A585 Windy Harbour to Skippool Improvement Scheme

6.5.2 ES Appendix 5.2: Section 42 Comments and Responses

ES APPENDIX 5.2: SECTION 42 COMMENTS AND RESPONSES

Regulation Number:	Regulation 5(2)(a)
Planning Inspectorate Scheme Reference	TR010035
Application Document Reference	TR010035/APP/6.5.2
Author:	A585 Windy Harbour to Skippool Improvement Scheme Project Team, Highways England

Figure 1-1: Existing Culvert Plan View

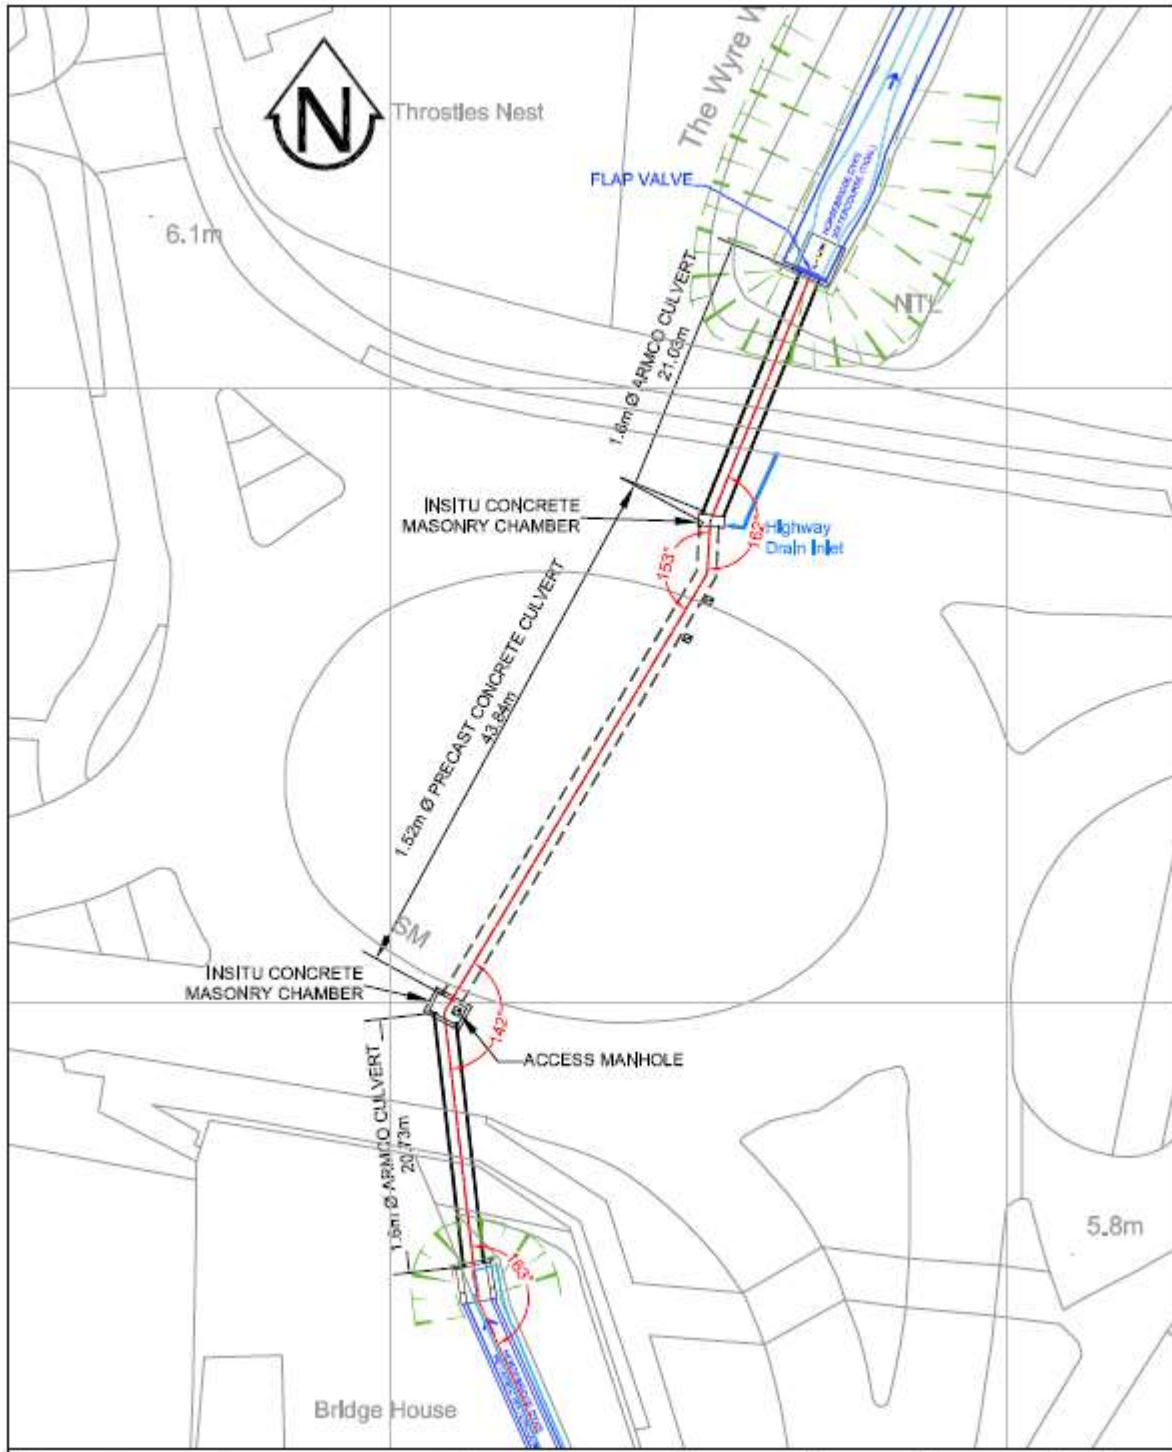
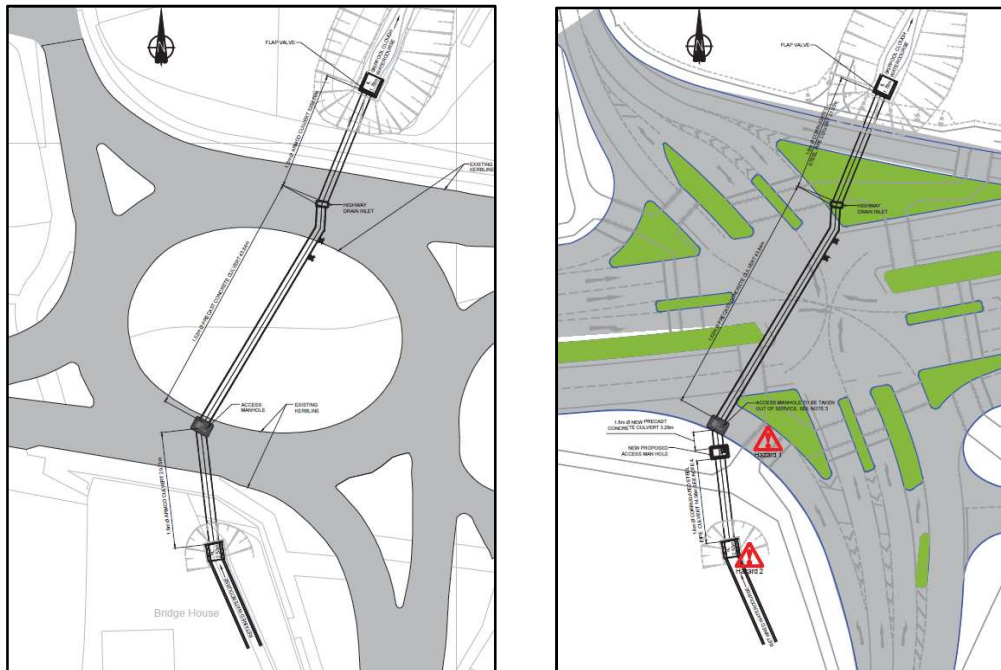
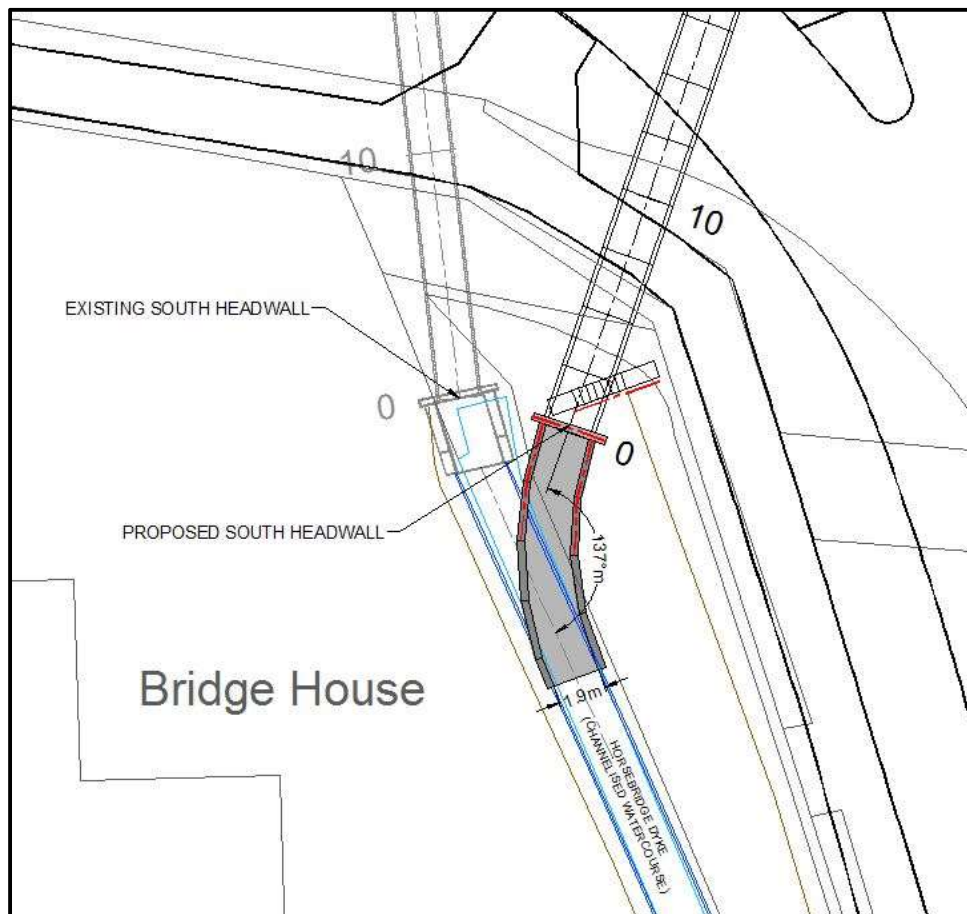
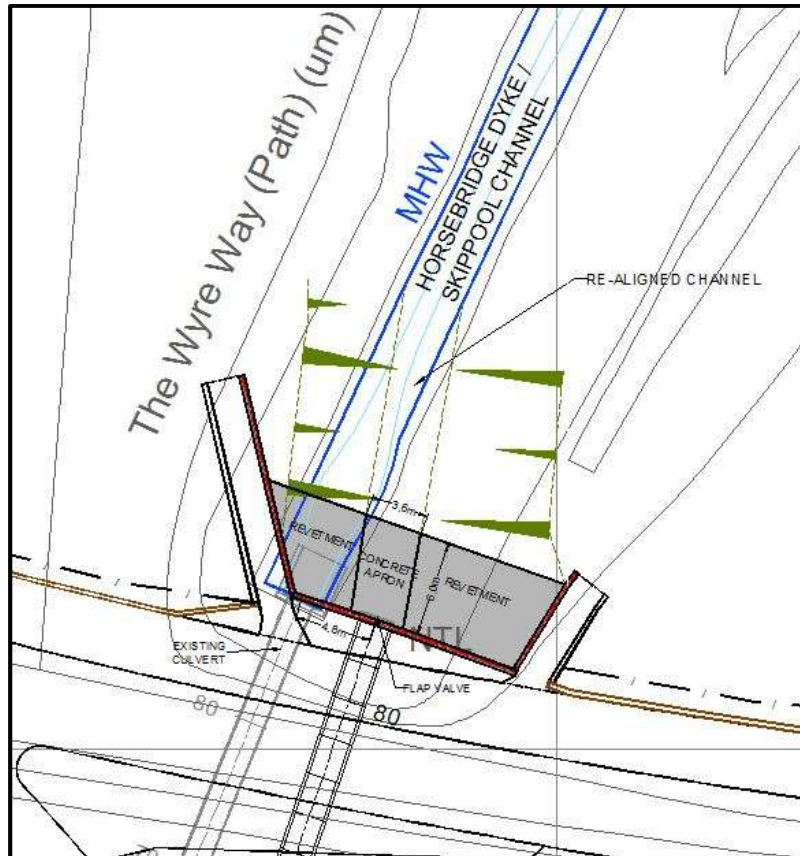
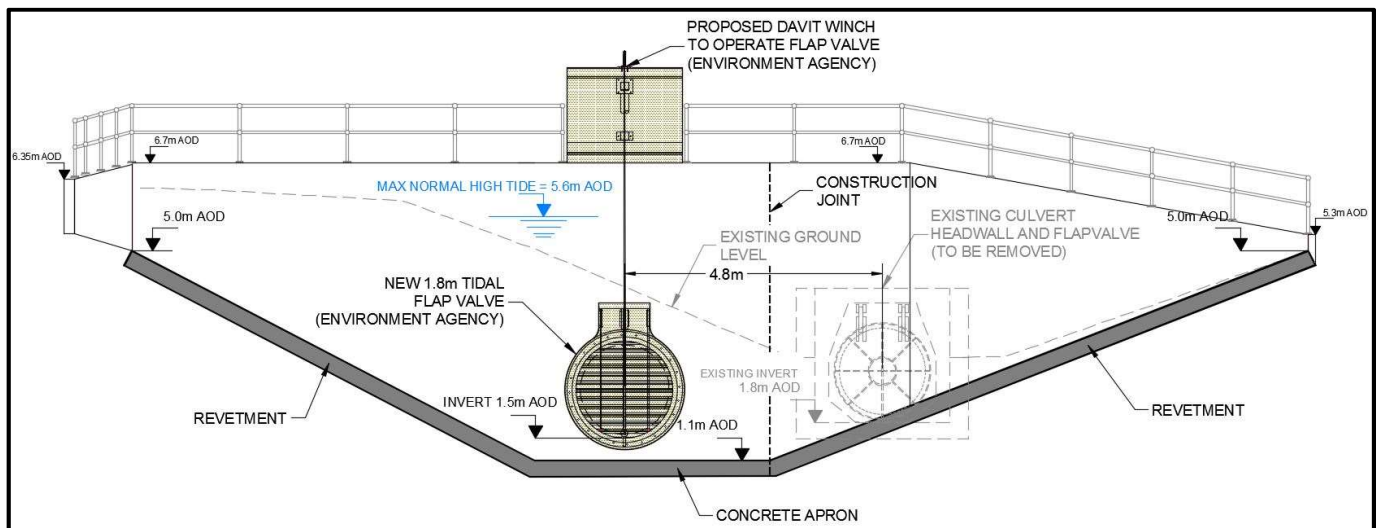
Consultee	Comment	Highways England Response
Environment Agency	<p>2.3 Scheme Alignment Paragraph 2.3.2 Page 7:</p> <p>Issue: Passing under the existing footprint of Skippool Junction roundabout is Skippool Clough Culvert carrying Horsebridge Dyke northwards towards the River Wyre at Skippool Creek. It is stated that this culvert would be retained in its present form under the new junction.</p> <p>Comment: If the capacity of the existing culvert is insufficient to convey peak flows associated with potential climate change impacts, the retention of the structure may increase flood risk to the proposed development.</p> <p>Suggested solution: Demonstrate that the capacity of the existing culvert is sufficient to convey peak flows associated with potential climate change impacts. If it is not, the existing culvert should be replaced to demonstrate how the increased risk of flooding over the lifetime of the development will be mitigated.</p>	<p>It has been identified that the existing culvert has limited life and needs to be replaced. A replacement culvert is proposed that would replace the existing culvert (minimum internal diameter 1.52m) with a new culvert (1.8m internal diameter) providing 40% increase in capacity.</p> <p>The effects of replacing the culvert would be considered in more detail in the next iteration of the FRA. More detailed numerical modelling assessment of the new culvert will be undertaken as necessary, and reported in the next iteration of the FRA.</p>

Environment Agency	<p>2.12 Demolition Paragraph 2.12.4, Page 14:</p> <p>Issue: Following a condition survey on Skippool Clough Culvert, it is possible sections of the culvert may need to be re-built if maintenance or strengthening works are not a suitable option. Options do not appear to include complete replacement of the culvert with a new structure.</p> <p>Comment: If the existing culvert is not fit for purpose, the retention and repair of the structure may not be appropriate and could increase flood risk.</p> <p>Suggested solution: Build a new structure that will be fit for purpose for the lifetime of the development (inclusive of accommodation of climate change peak flow allowances) should maintenance and strengthening works to the existing Skippool Clough Culvert not be sufficient to mitigate the flood risk.</p>	<p>It has been identified that the existing culvert has limited life and needs to be replaced. A replacement culvert is proposed that would replace the existing culvert (minimum internal diameter 1.52m) with a new culvert (1.8m internal diameter) providing 40% increase in capacity.</p> <p>The effects of replacing the culvert would be considered in more detail in the next iteration of the FRA. More detailed numerical modelling assessment of the new culvert will be undertaken as necessary and reported in the next iteration of the FRA.</p>

Project A585 WINDY HARBOUR TO SKIPPOOL IMPROVEMENT SCHEME
Drawing Title ENVIRONMENTAL STATEMENT REGULATION 5(2)(a) ROAD DRAINAGE AND WATER ENVIRONMENT: WATERBODIES AND ENVIRONMENT AGENCY FLOOD ZONES

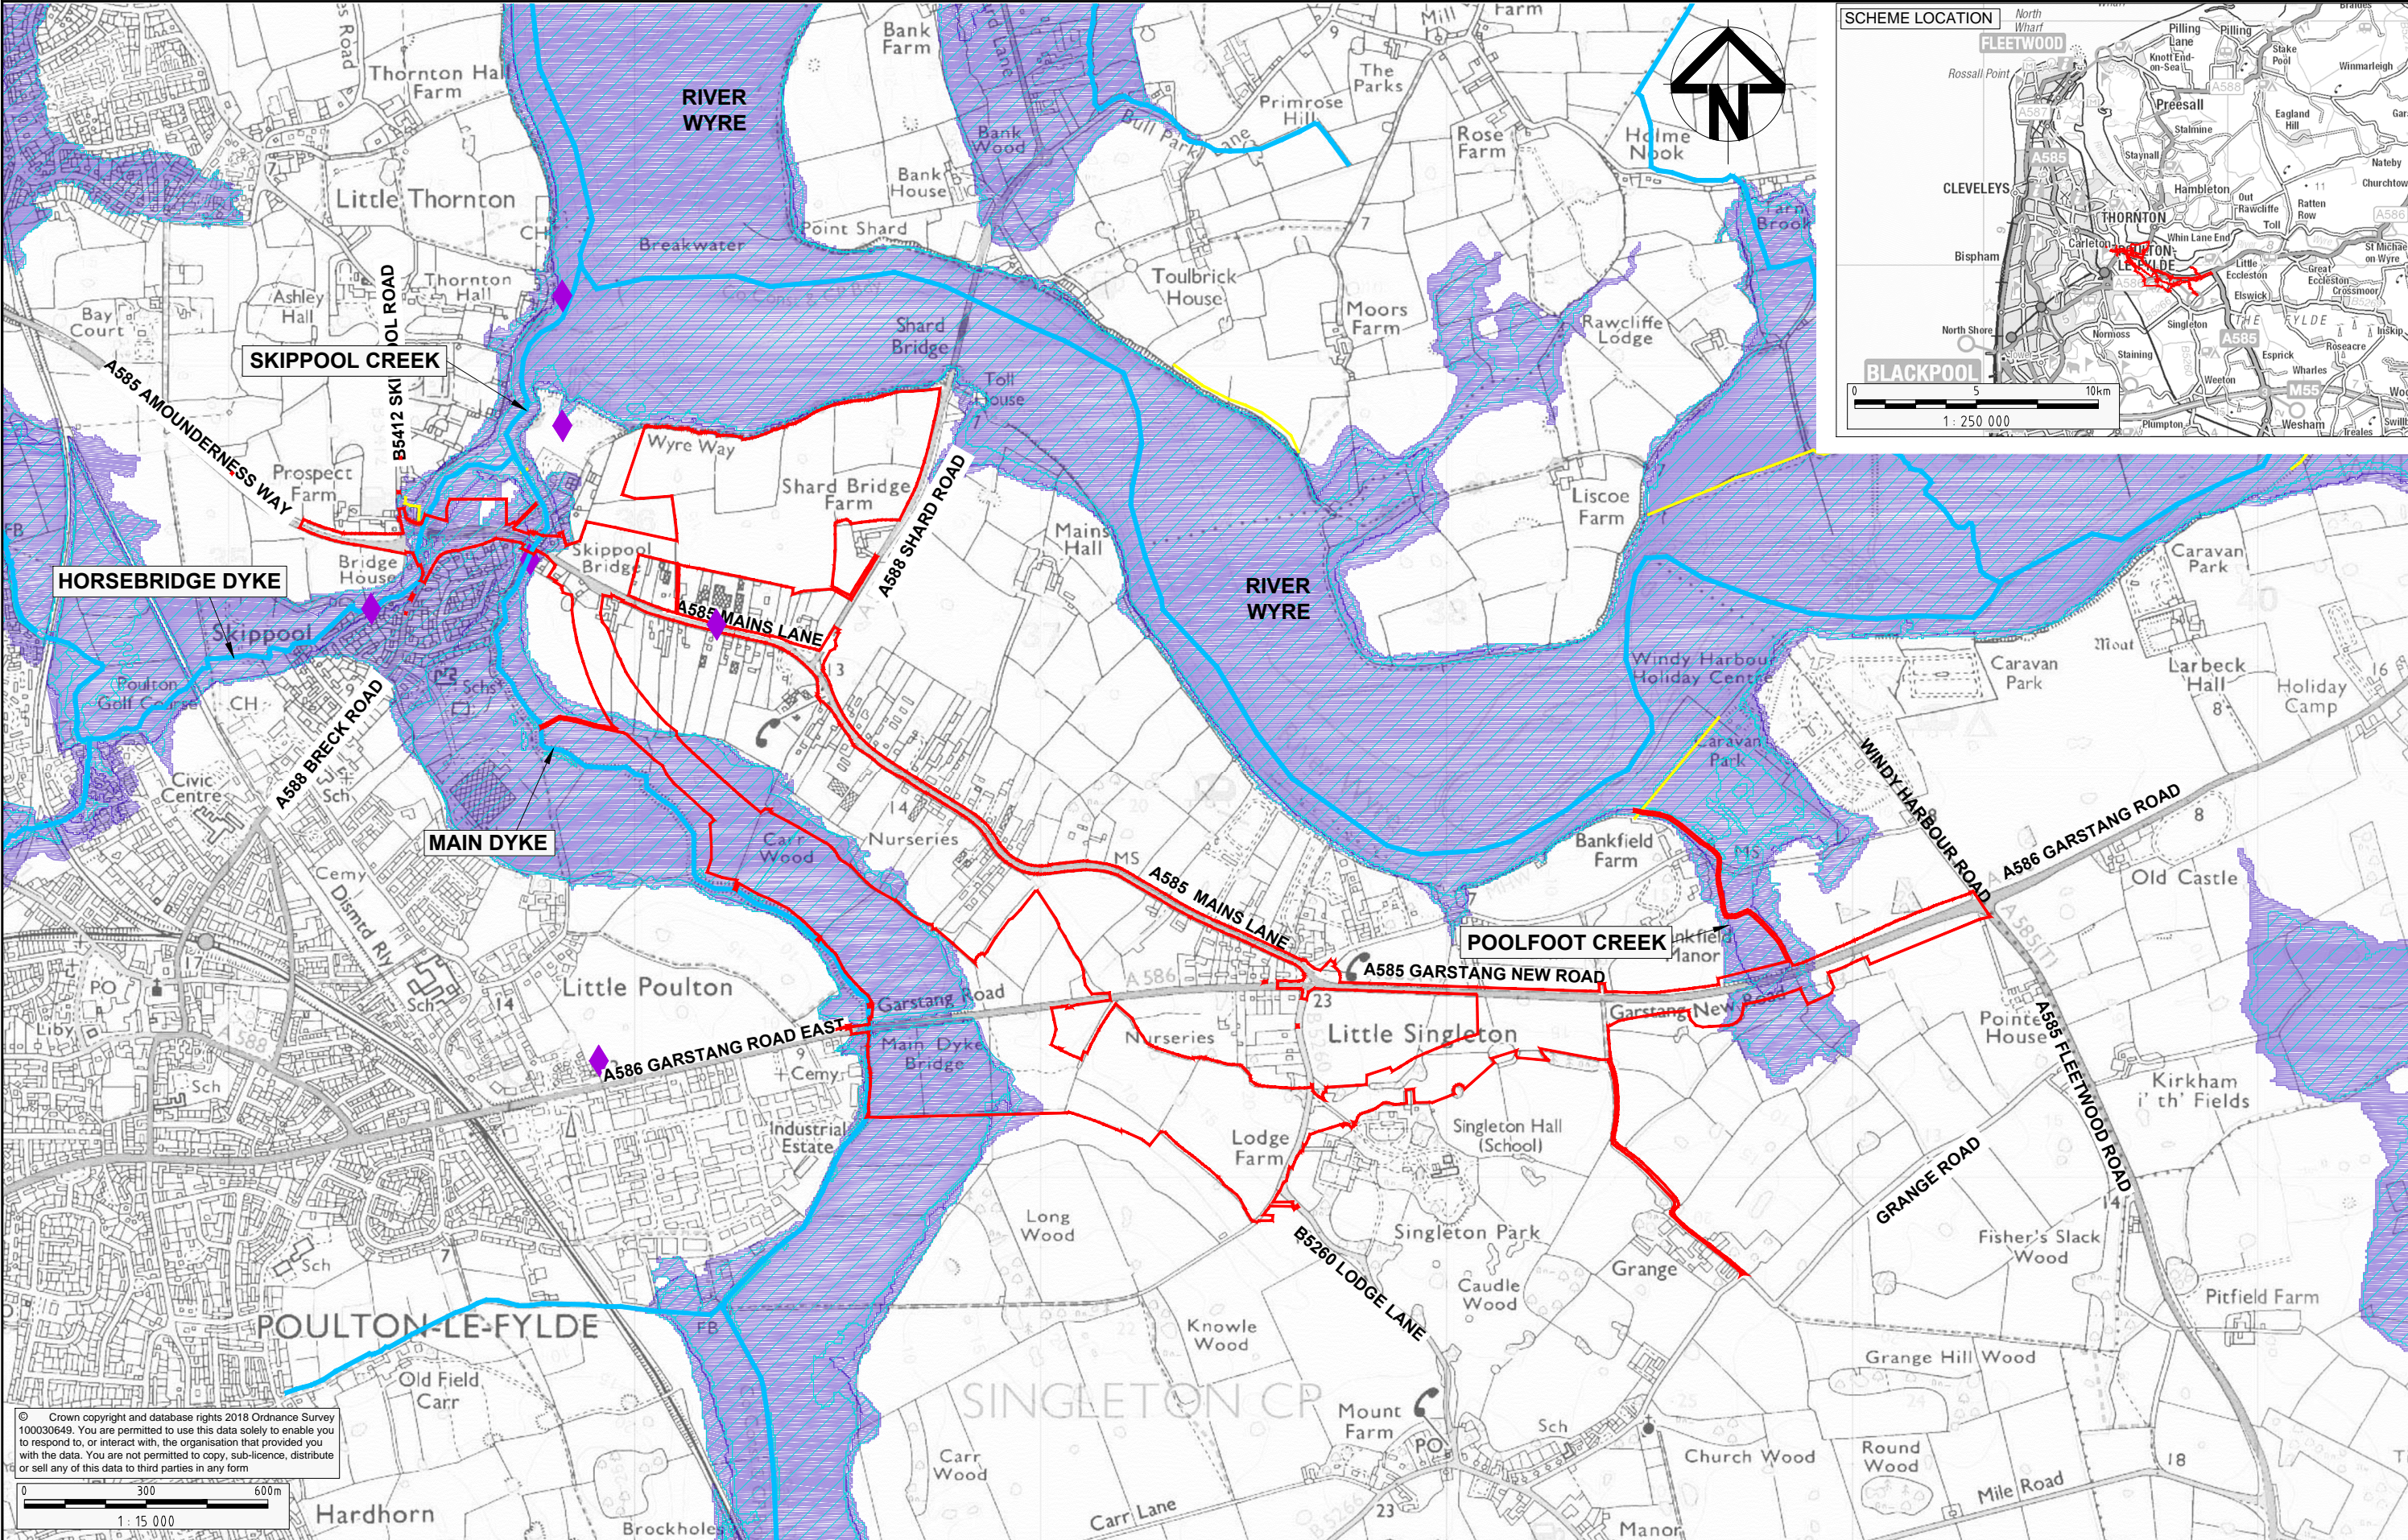
Consultee	Comment	Highways England Response
Environment Agency	<p>2.4 Earthworks Design, Paragraph 2.4.1, Page 9:</p> <p>Issue: To achieve the required profile, there are various locations the route goes into cutting or requires fill. We anticipate that this will be dealt with in detail as part of the Flood Risk Assessment (FRA) component. However, information is lacking at present to give a clearer picture on exactly where these cut and fill locations are and what the relationship is to the flood zone designation. At present only drawing 5 of 5 in Appendix A (8 of 9), superimposes the scheme onto modelled Flood Zone 2 and 3 constraints.</p> <p>Comment: The effects of the proposal on flooding regimes and flood flow routes during the construction and operation phases across a range of modelled return periods are unknown.</p> <p>Suggested solution: Additional drawings should be produced that clearly show scheme proposal in Flood Zones 2 and 3. In order that extent and type of proposal are better understood at an early stage.</p>	<p>This information forms part of the FRA (document reference TR0010035/APP/5.2) Chapter 12: Road Drainage and the Water Environment (document reference TR0010035/APP/6.12), Figure 12.1.</p>
